CITY OF PORTLAND BUILDING PERMIT

Located At 727 CONGRESS ST

Job ID: 2012-04-3711-ALTCOMM

has permission to Replace rear deck & add deck dormer to 4th Floor of Unit #8
provided that the person or persons, firm or corporation accepting this permit shall comply with all of the provisions of the Statues of Maine and of the Ordinances of the City of Portland regulating the construction, maintenance and use of the buildings and structures, and of the application on file in the department.

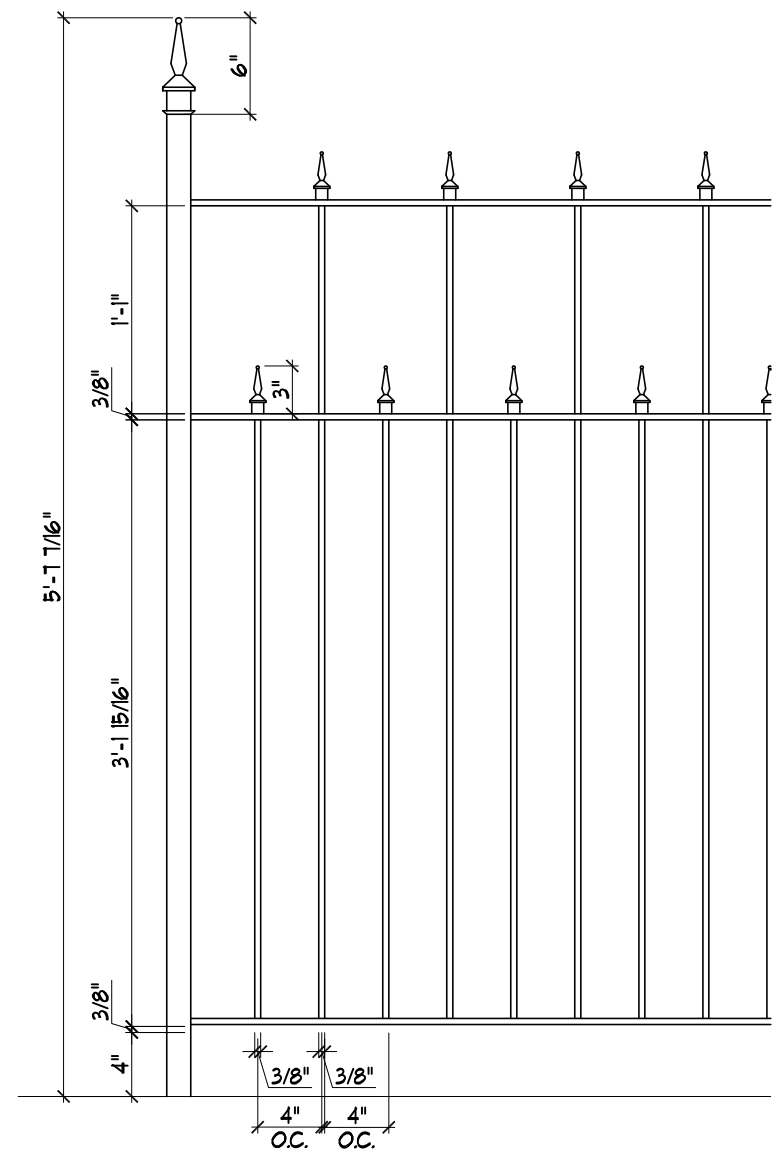
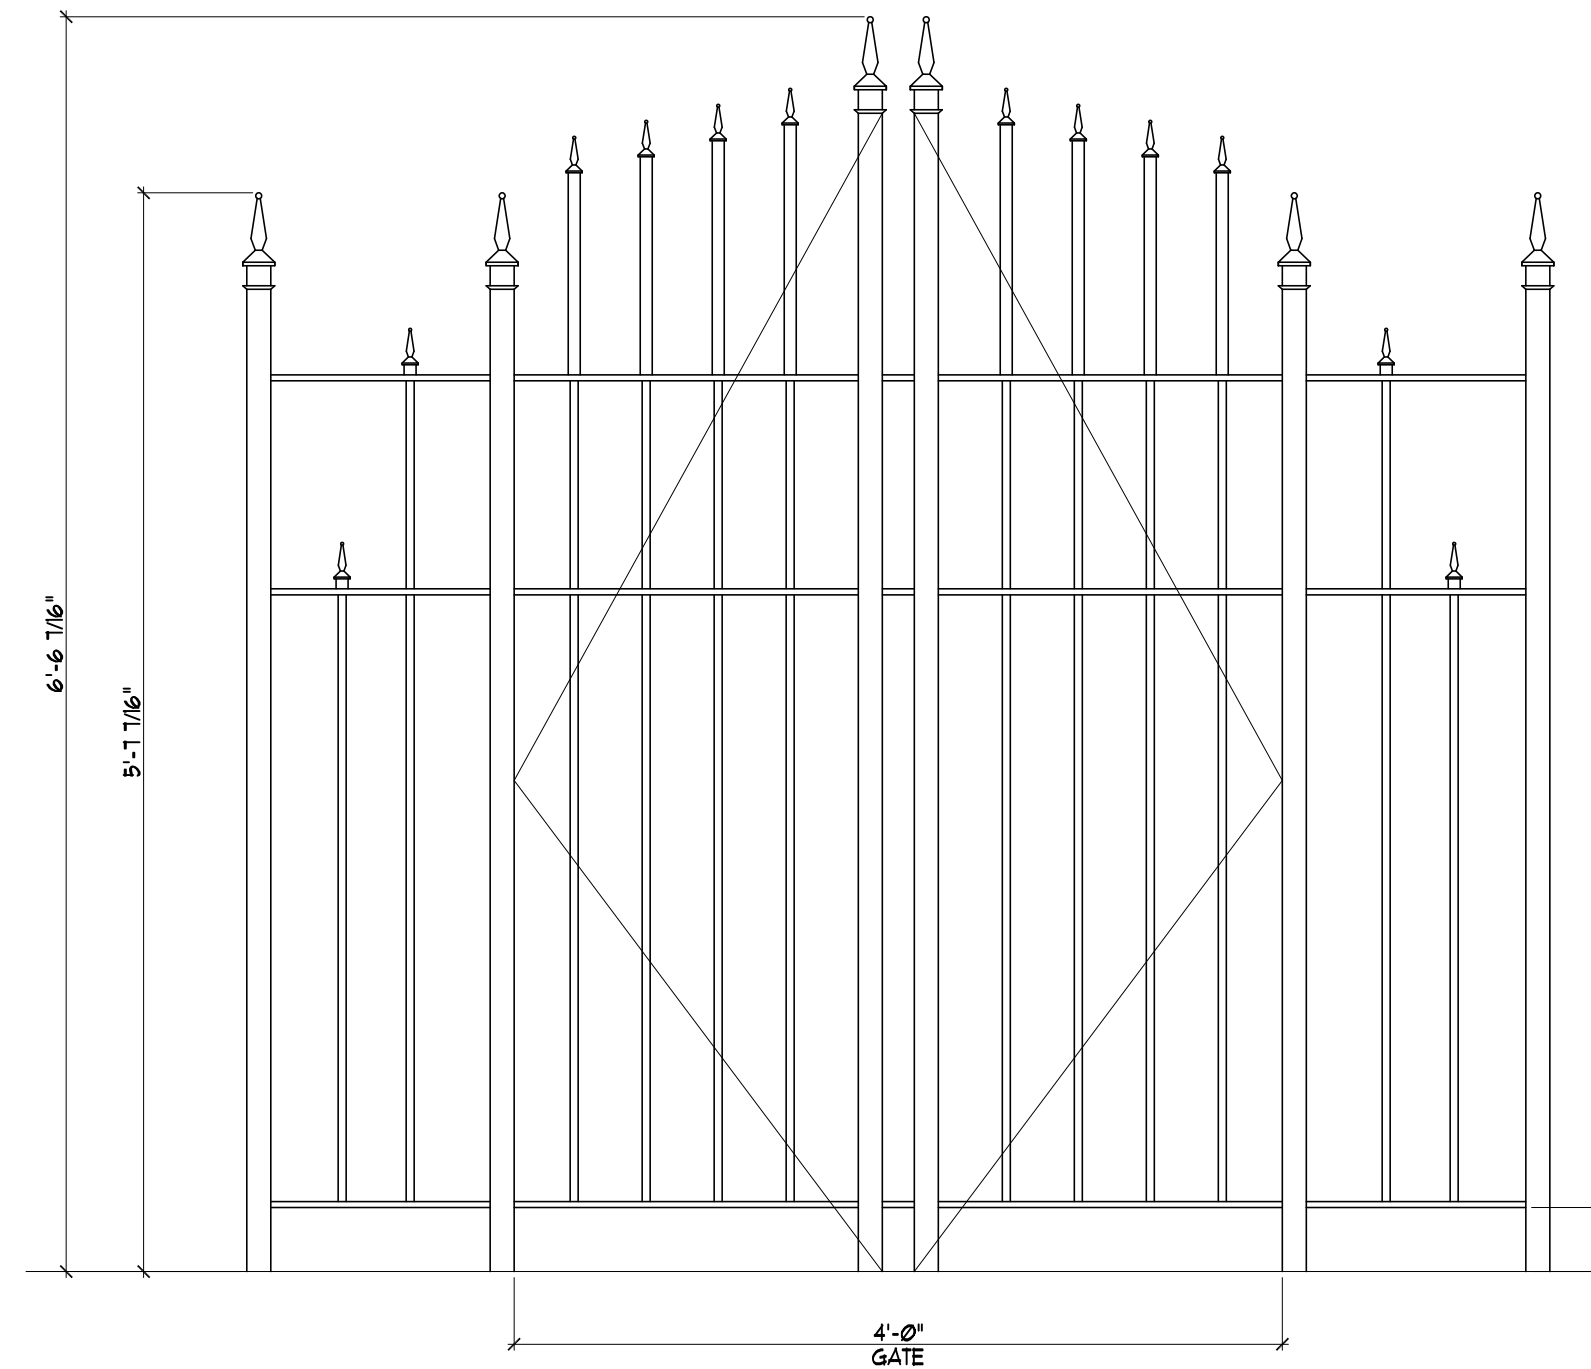
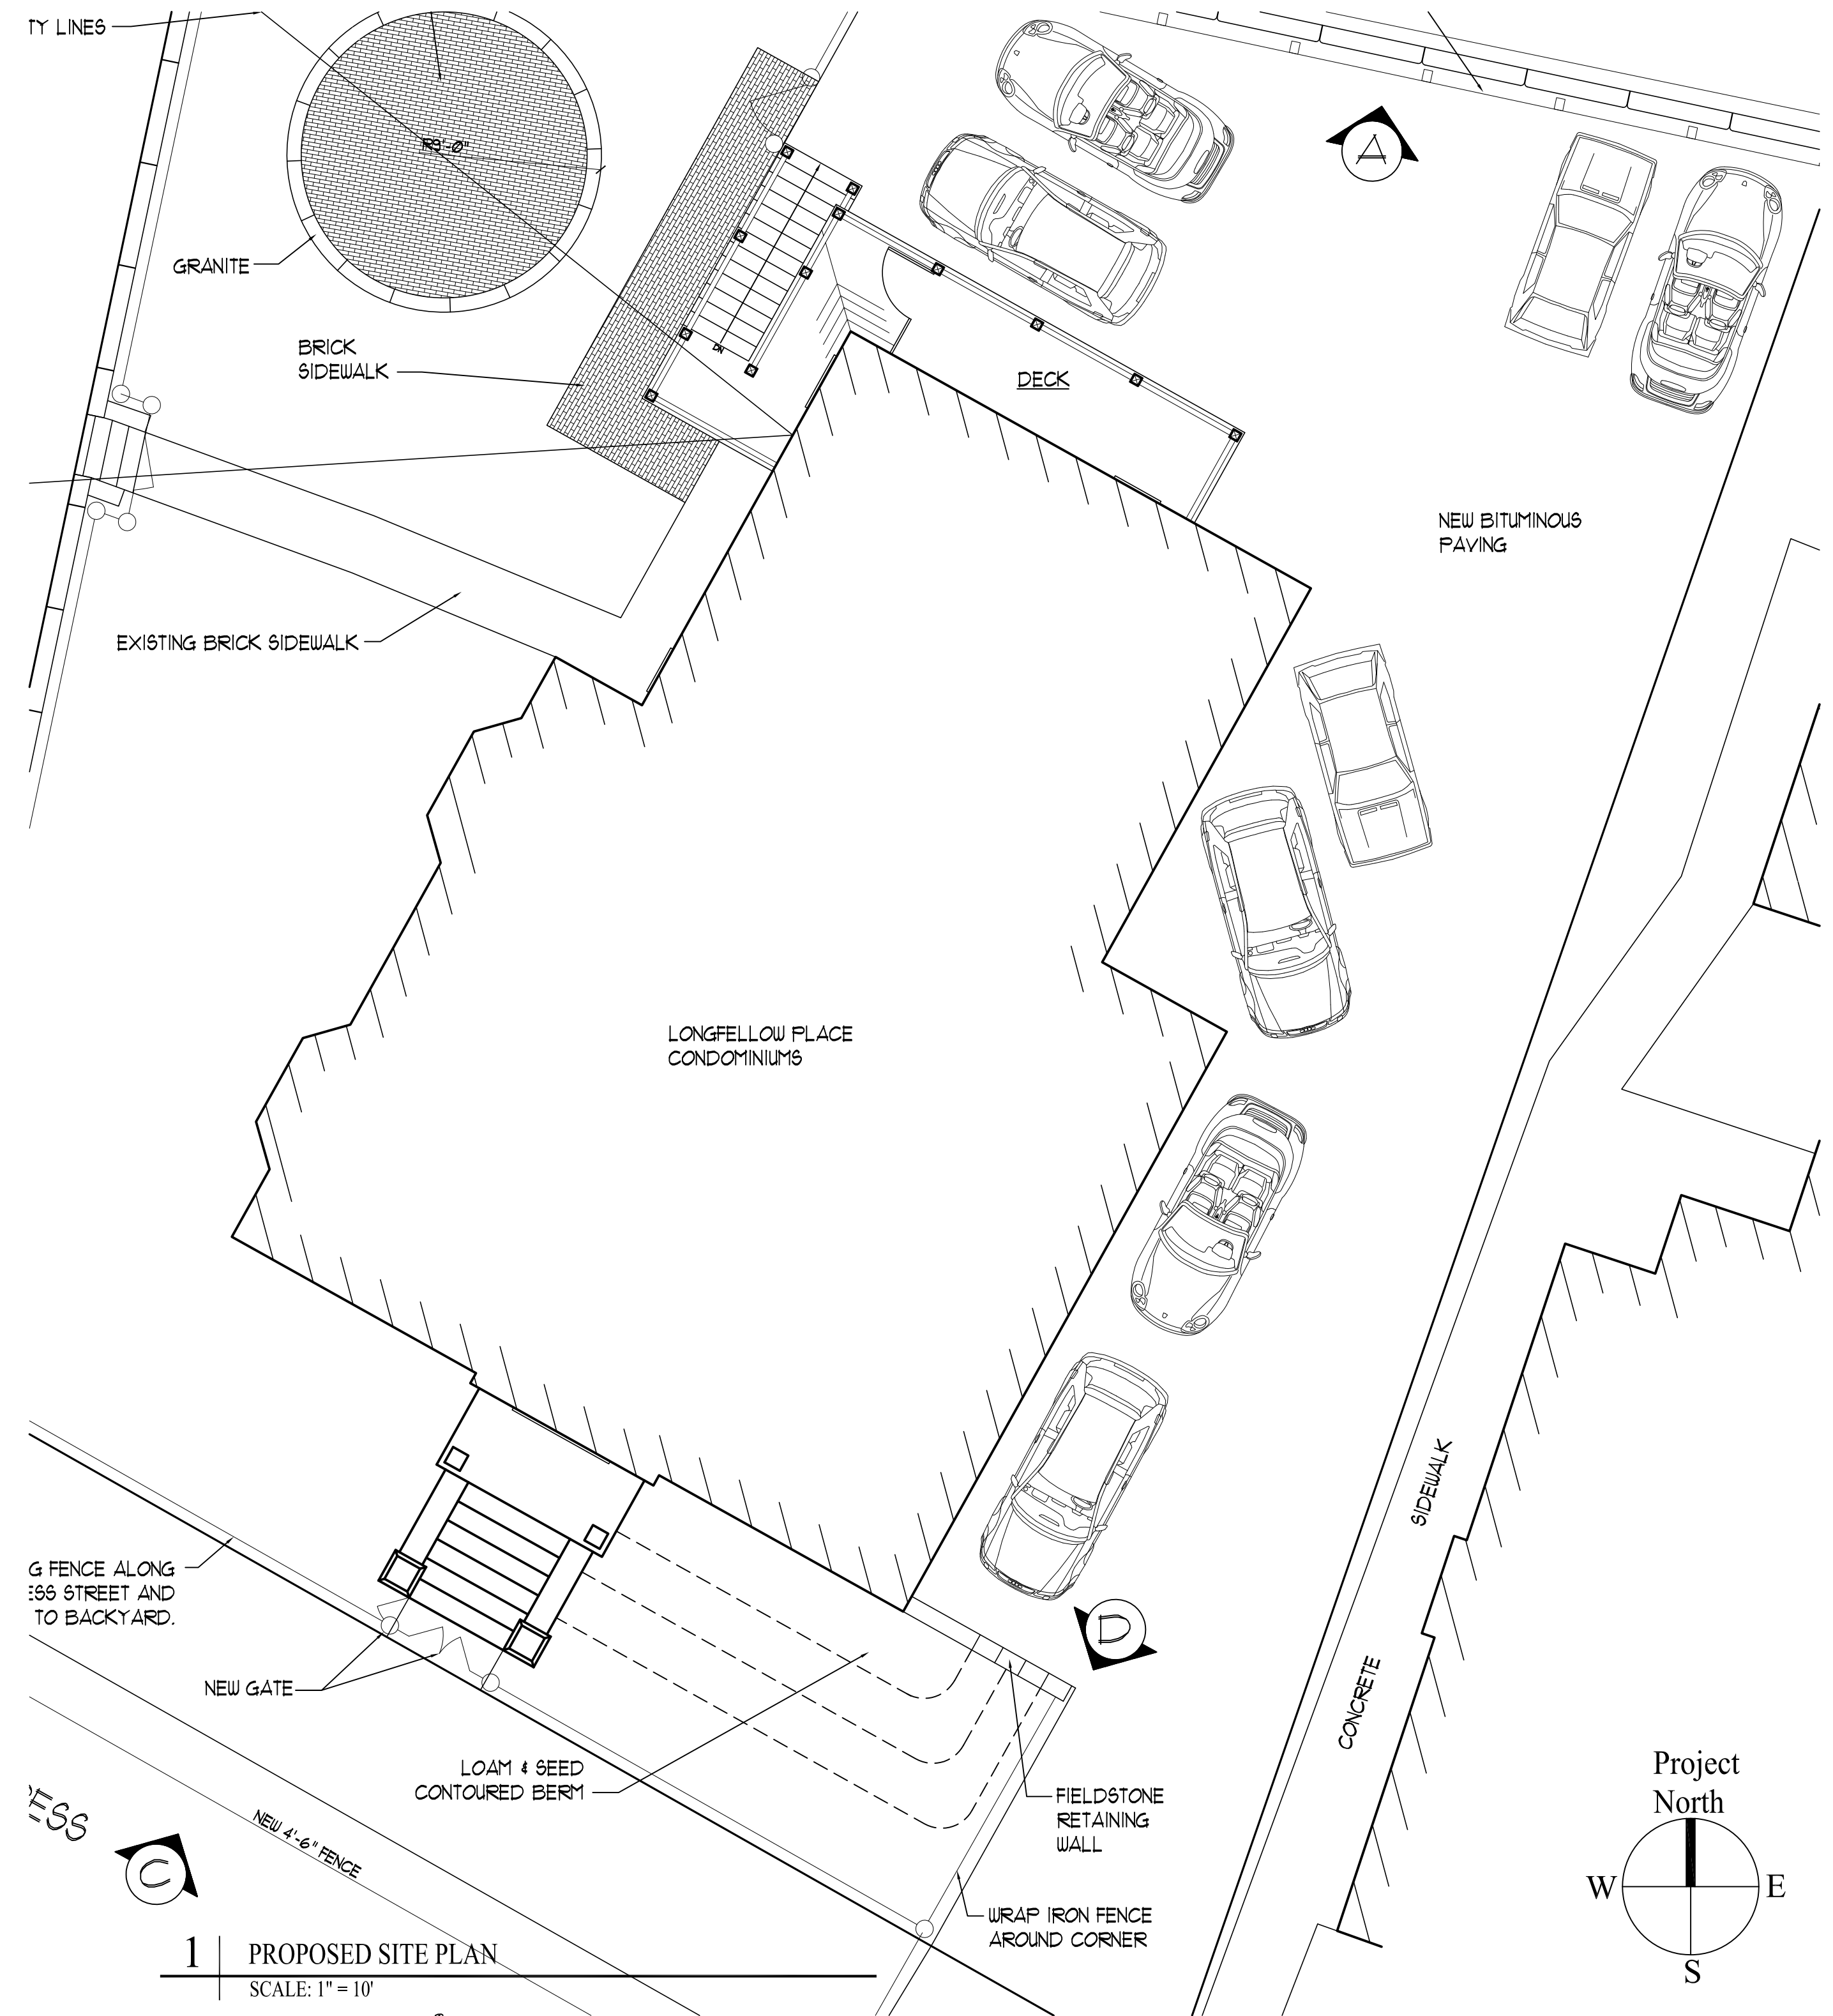
On the back deck/stairs the design for the balustrade has 2 issues in relation to the requirement for a graspable handrail:

1. the size of the top rail is too large and
2. it is not continuous due to newel interruption

Would you be amenable to adding a graspable handrail on brackets at 34" ^{38"} on one side of the stair, normally it is required on both sides.

1. Application approval based upon information provided by applicant. Any deviation from approved plans requires separate review and approval prior to work.
2. Separate permits are required for any electrical, plumbing, sprinkler, fire alarm, HVAC systems, heating appliances, including pellet/wood stoves, commercial hood exhaust systems and fuel tanks. Separate plans may need to be submitted for approval as a part of this process.
3. This permit is approved per IBC 2009 Section 3409.1 for existing historic buildings; guardrail height allowance is a minimum of 36".
4. ONE GRASPABLE HANDRAIL WITH RETURNED ENDS MEASURED 34"-38" FROM THE NOSING IS REQUIRED AT THE REAR EGRESS STAIRS. THIS HAS BEEN APPROVED BY HISTORIC (DEB A.).
